SUBJECT: **BRES2112-0027**
BUILDING RESIDENTIAL

Here are the results of all Inspections located at **49 ALICE HOLLEMAN LN:**

Floor System layout

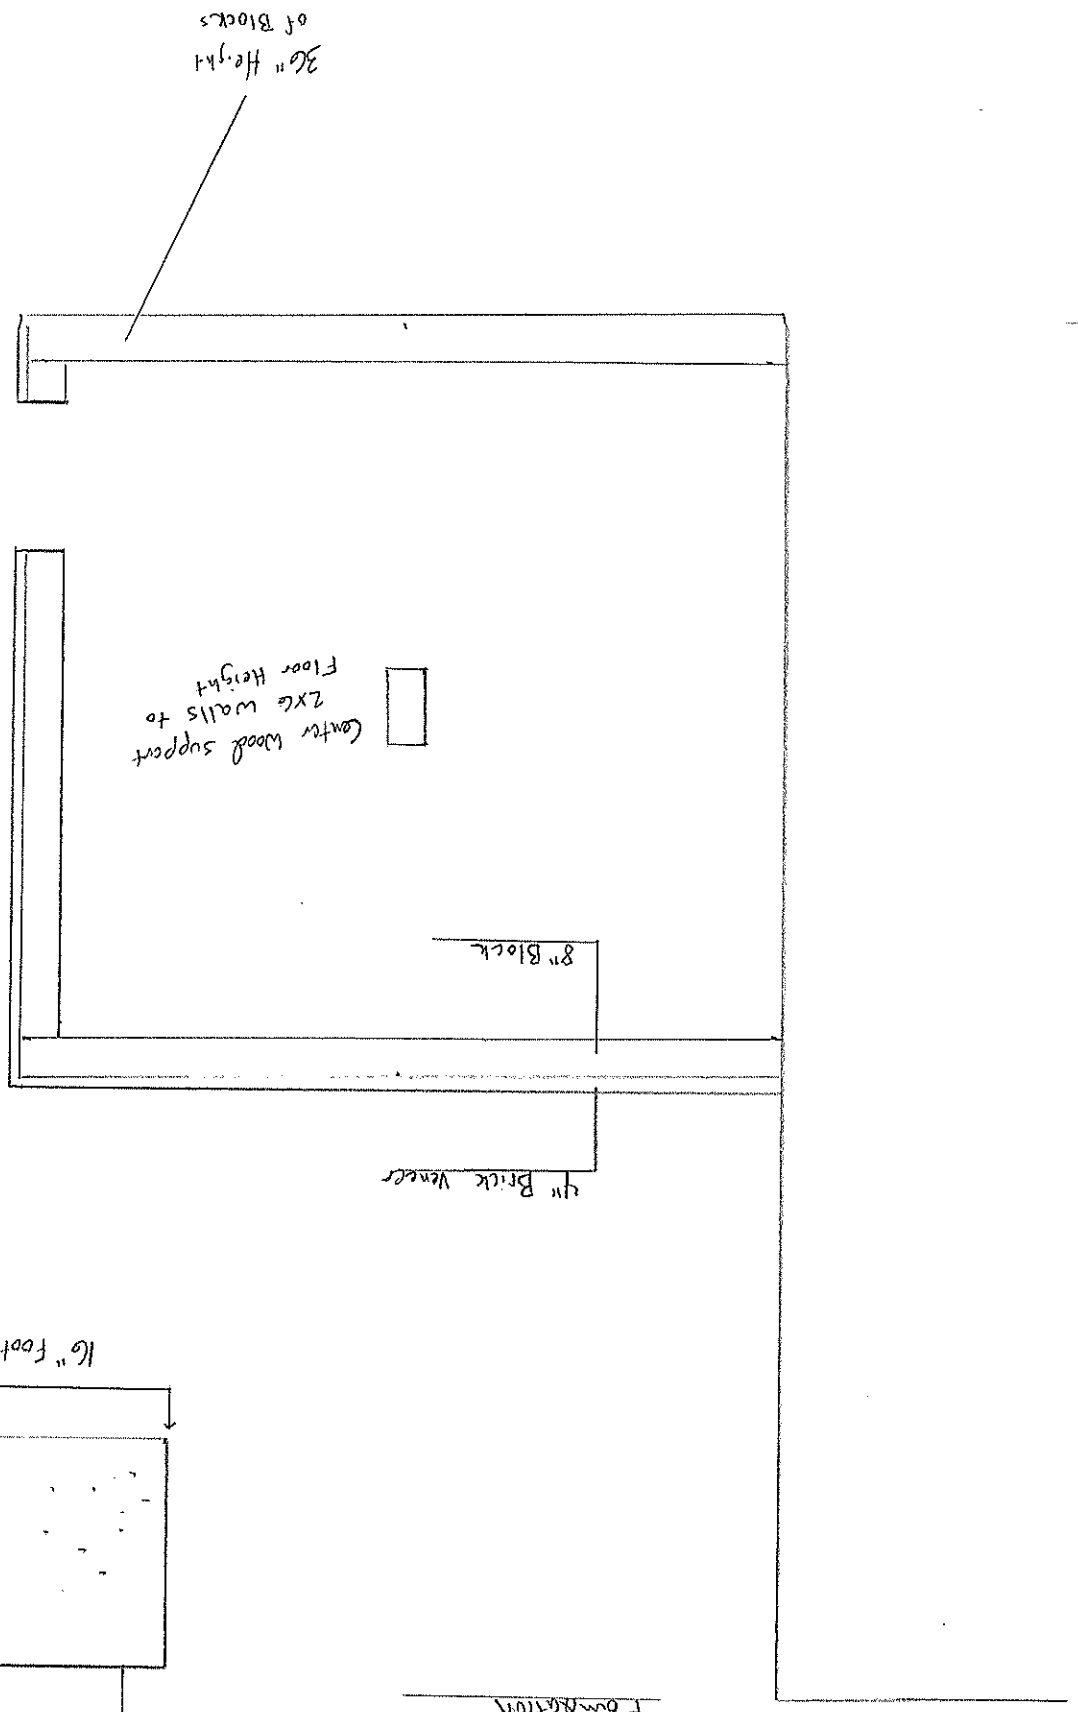
Inspection Type: ROUGH IN
Scheduled Date/Time: 7/5/2022
Completed Date/Time: 7/5/2022
Inspector: Justin Ryan McLeod
Result: DISAPPROVED
Remarks:
Notes: 1, fire caulk all penetrations through top plate. 2. Hurricane clips need installing on each truss.
3. Attach rear band to original house band with 1/2 bolts or structural screws.
1, fire caulk all penetrations through top plate. 2. Hurricane clips need installing on each truss.
3. Attach rear band to original house band with 1/2 bolts or structural screws. 4. will need structural engineer letter to see if the jack post supporting the 3 ply girder in crawl is sufficient for the application and the 3 ply girder not breaking over a load support.
